LAWRENCE R. PILON, PE

August 5, 2021

Re: Anchors Offset on Footings
Sheetz 24'3/4' x 150' (12) Column Fuel Island Radius Front Canopy
283 NC Rte 87, Cameron, NC 28326
McGee Drawing # 59914

FOUNDATION PLAN

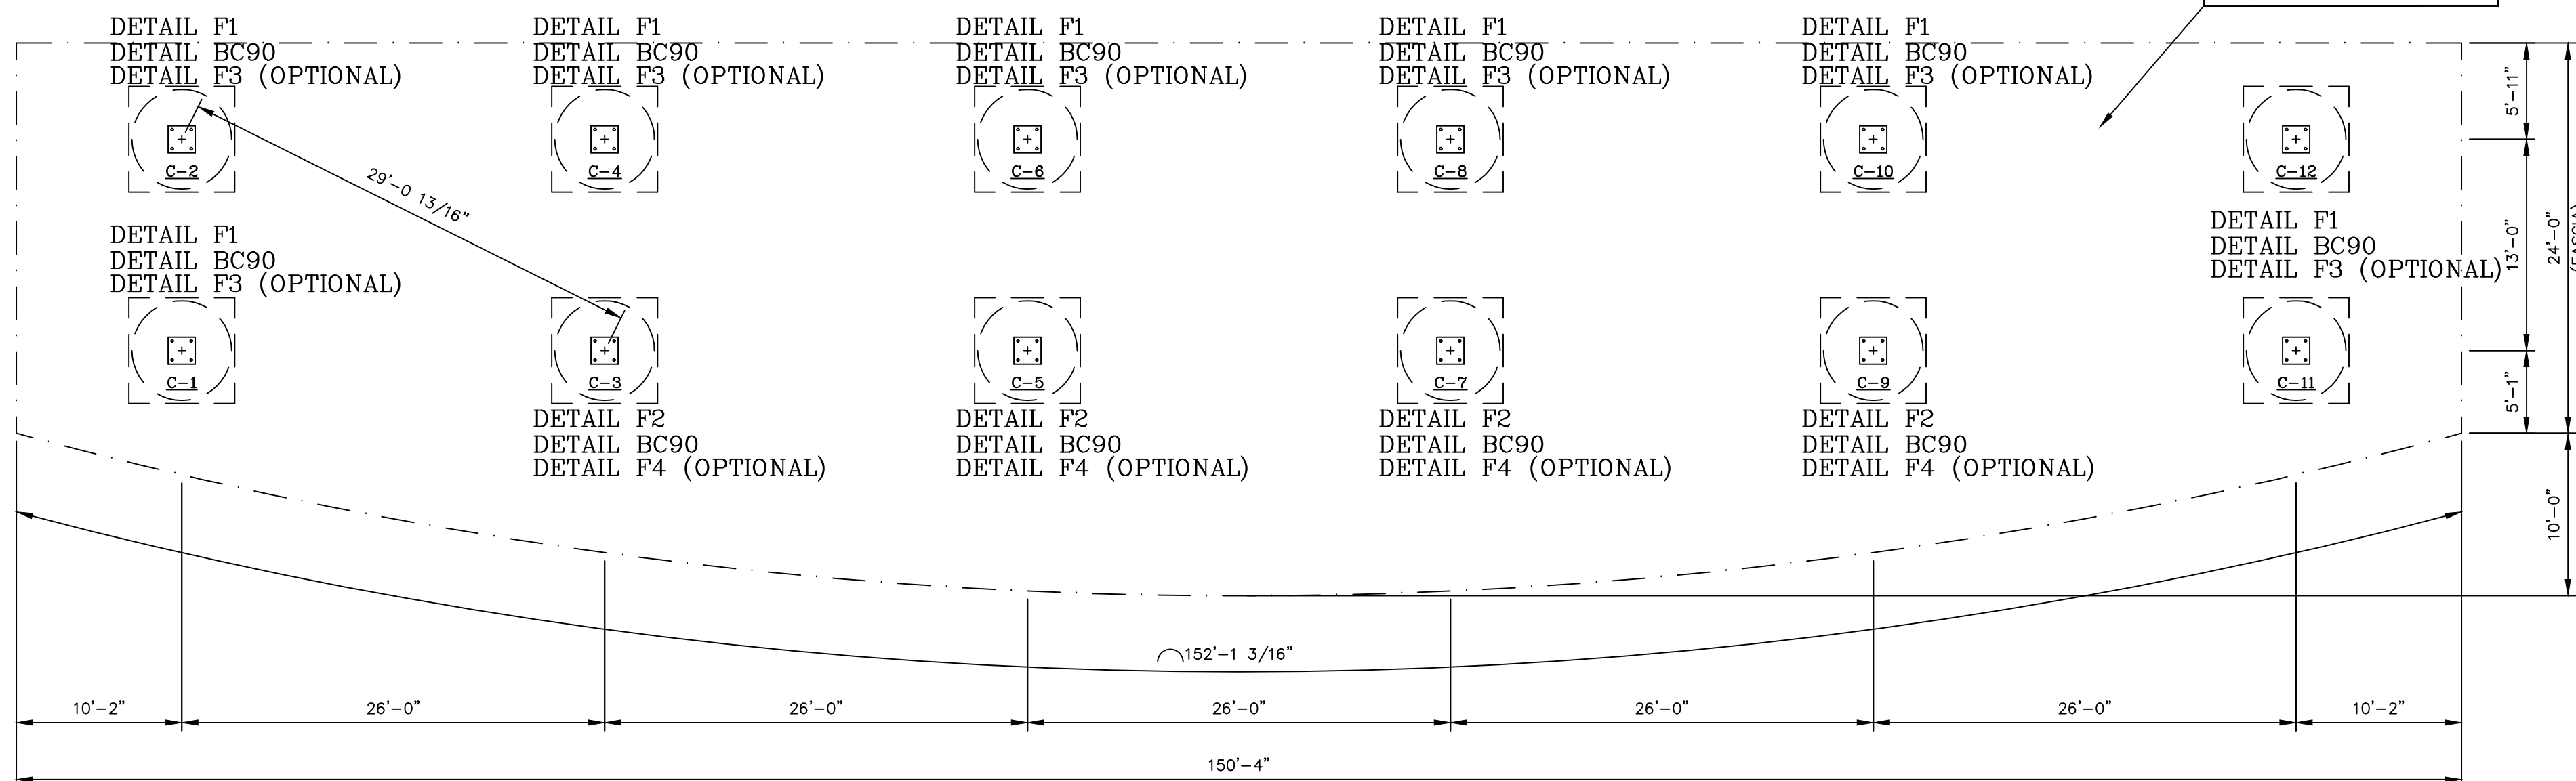
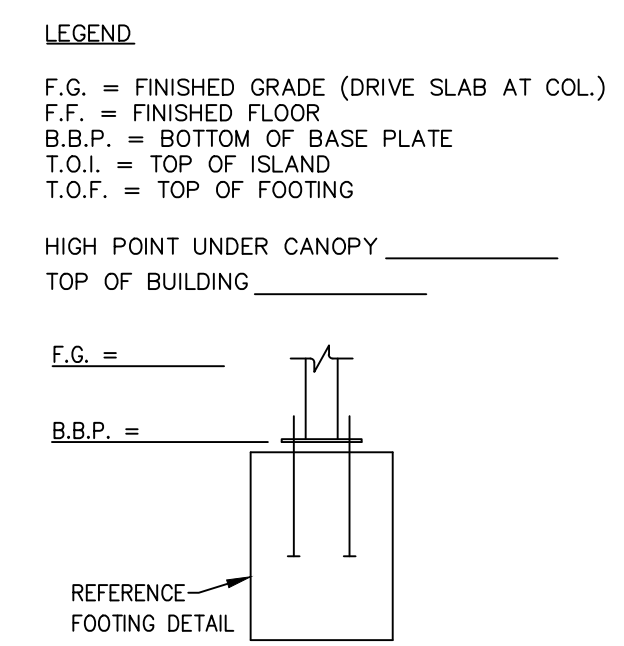
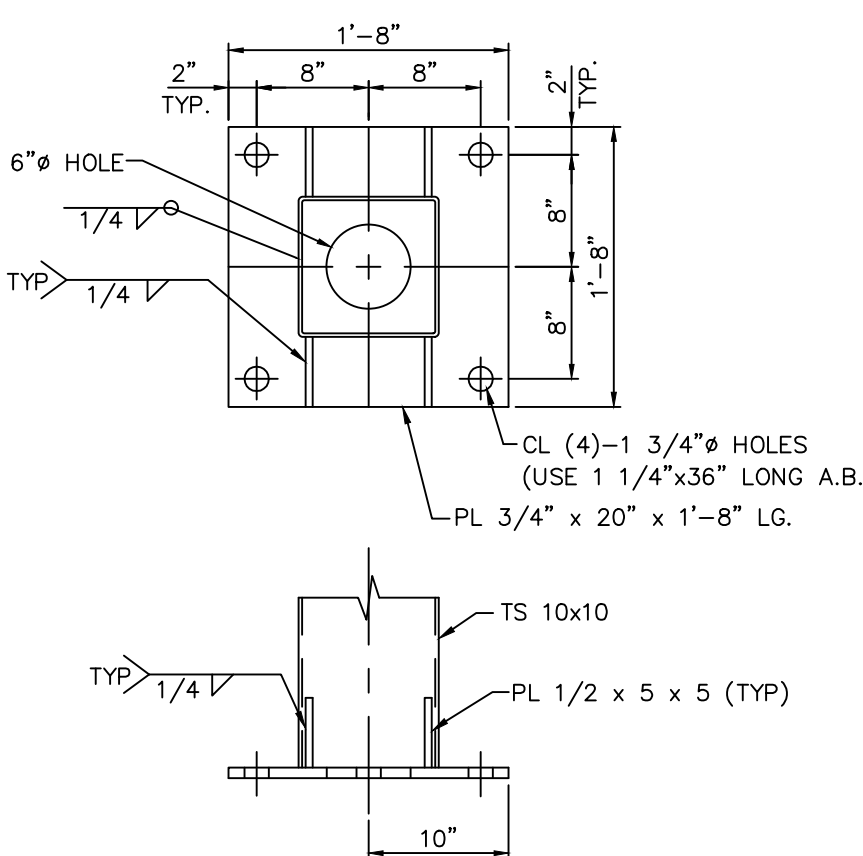
This letter provides verification that it is considered structurally acceptable for the subject canopy anchor group centerlines, as shown on drawings sealed by me on 2/5/21, to be offset from the center of the canopy foundations by up to 6". Canopy column centerline spacing should remain as shown on the subject drawings with the anchor group offsets.
